# CITY OF ALBUQUERQUE

RE: **Beehive Homes** - SW Corner Four Hills Road and Wenonah NE **L23/D022**  
Four Hills Village Shopping Center, Tract 1-B2 **PE Stamp: 10/4/2013**  
**Grading & Drainage Plan** for Grading Permit, Building Permit and SO-19

Notes on the 10-4-2013 Plan

ENGINEER'S SEAL	BEEHIVE HOMES	DRAWN BY WCUJ
DAVID SOULE NEW MEXICO REGISTERED PROFESSIONAL ENGINEER 14522	GRADING AND DRAINAGE PLAN	DATE 10-02-13
	Rio Grande Engineering 1606 CENTRAL AVENUE SUITE 201 ALBUQUERQUE, NM 87106 (505) 872-0999	21227-AYOUT-7-13-12
		SHEET # 1
		JOB # 21227

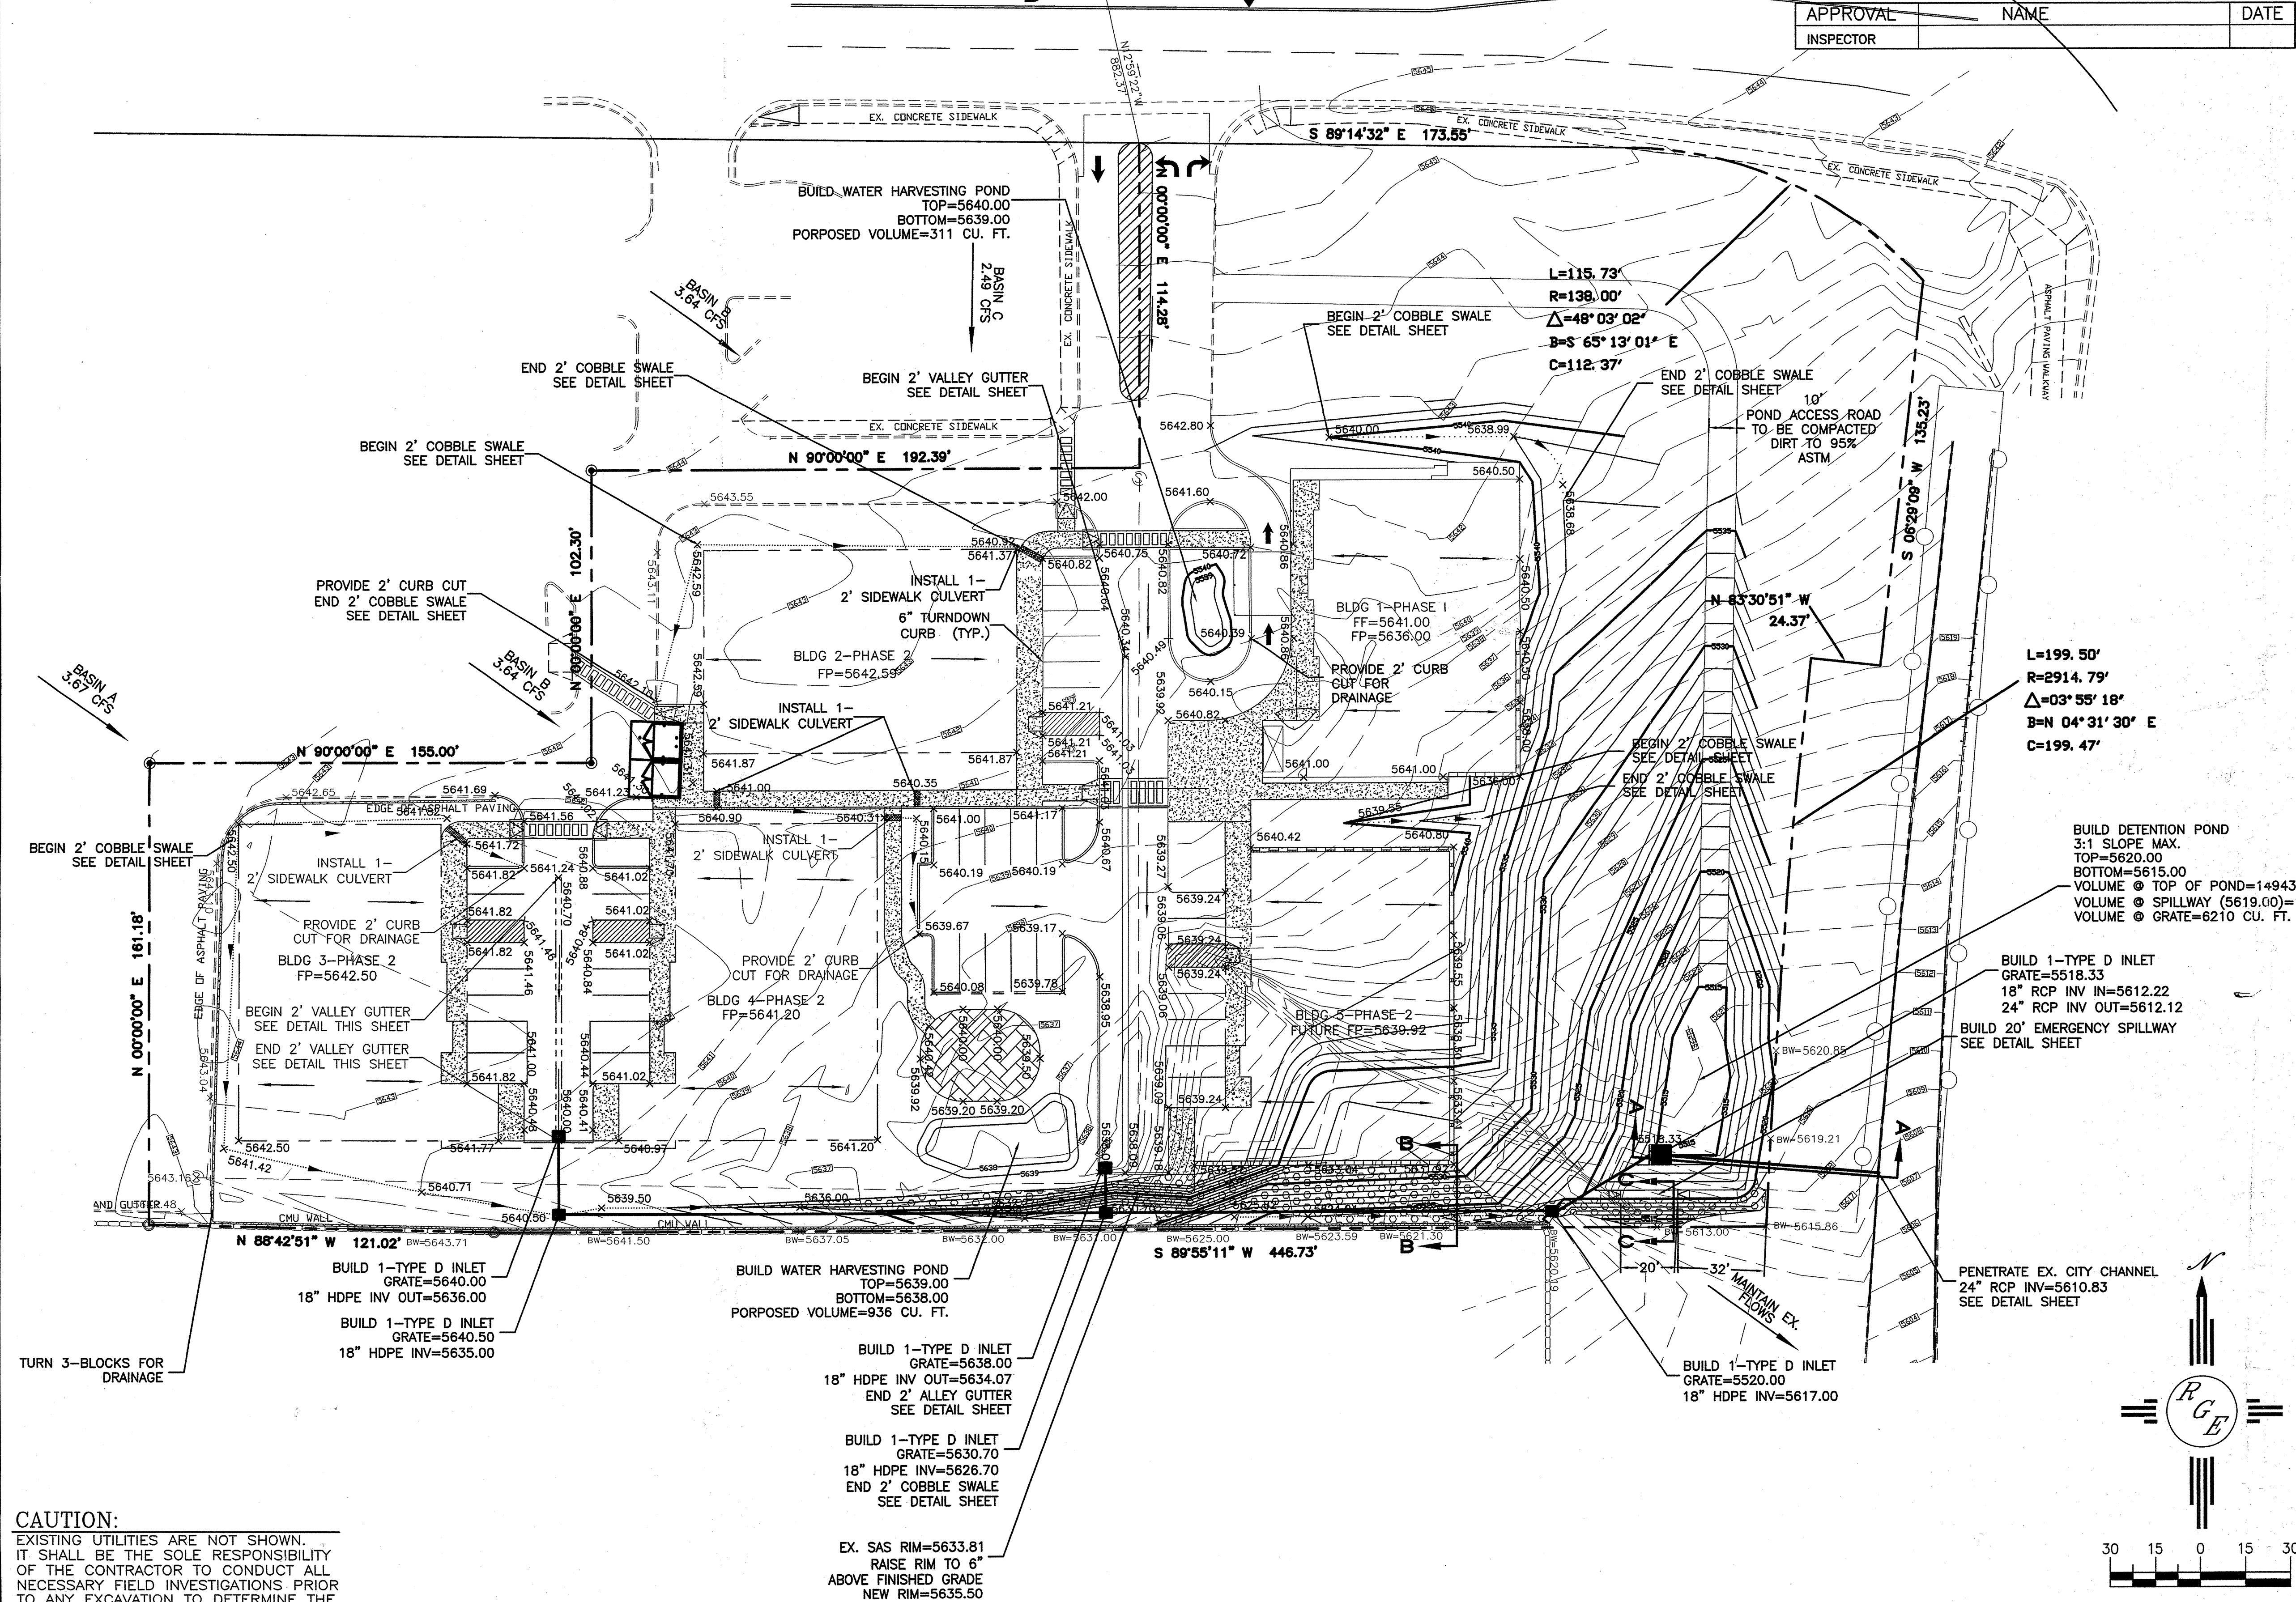
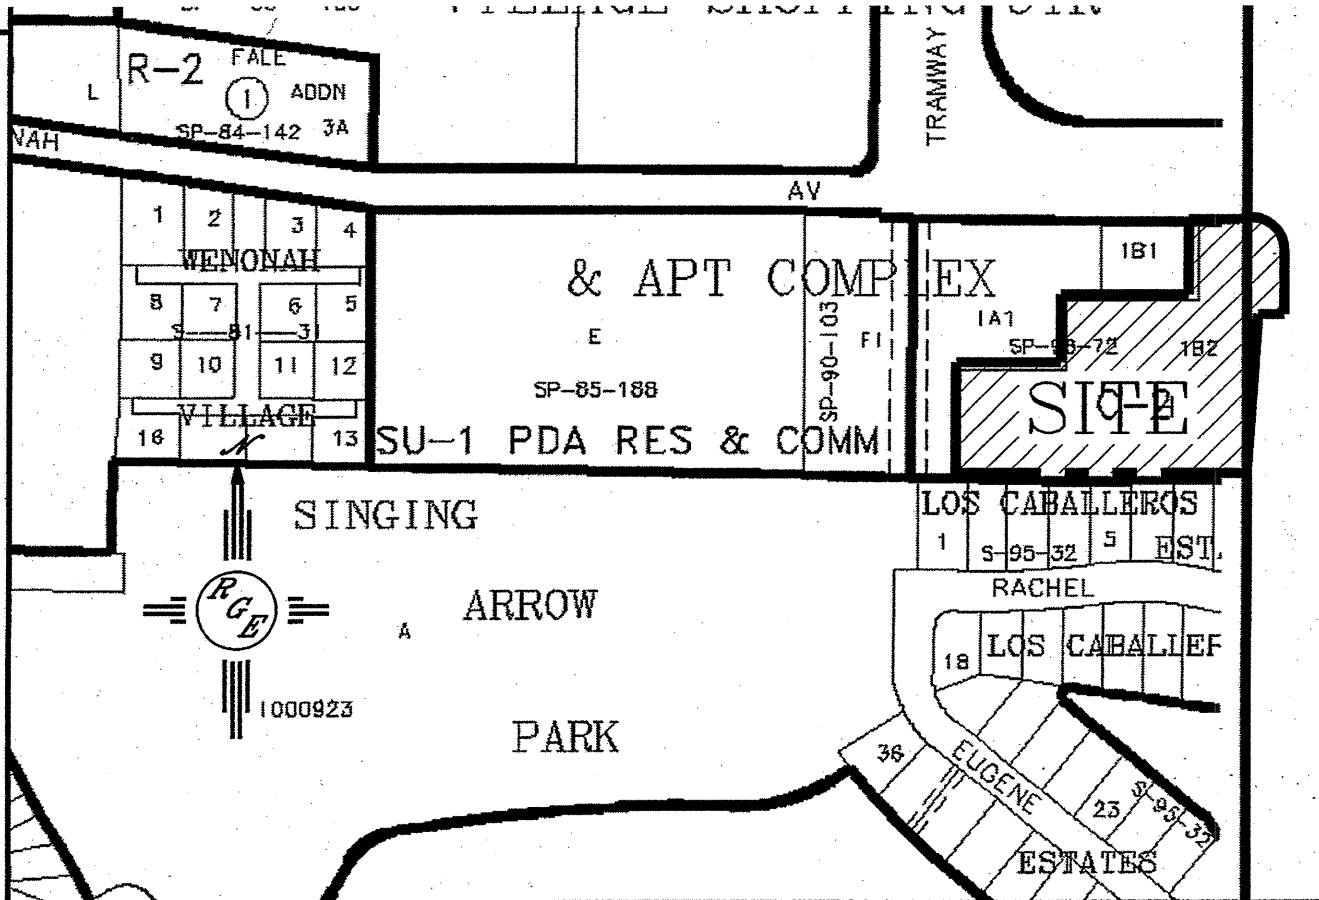
Thank you for your persistence in finalizing this design. As you know I am particularly concerned for the integrity of the vertical wall channel, and the proposed penetration.

1. Blow-up on Section A-A: I would suggest adding some rings of rebar (2-#4's?) in the concrete collar outside the channel wall to strengthen the Concrete Collar.
2. Section A-A: The main section still says Encase n Lean Fill, while the blow-up calls for Concrete. Please correct and initial the requirement for concrete.
3. Were you going to use Lean Fill to bed the pipe beyond the Collar? (Note 7 from my 10/3/13 Email)
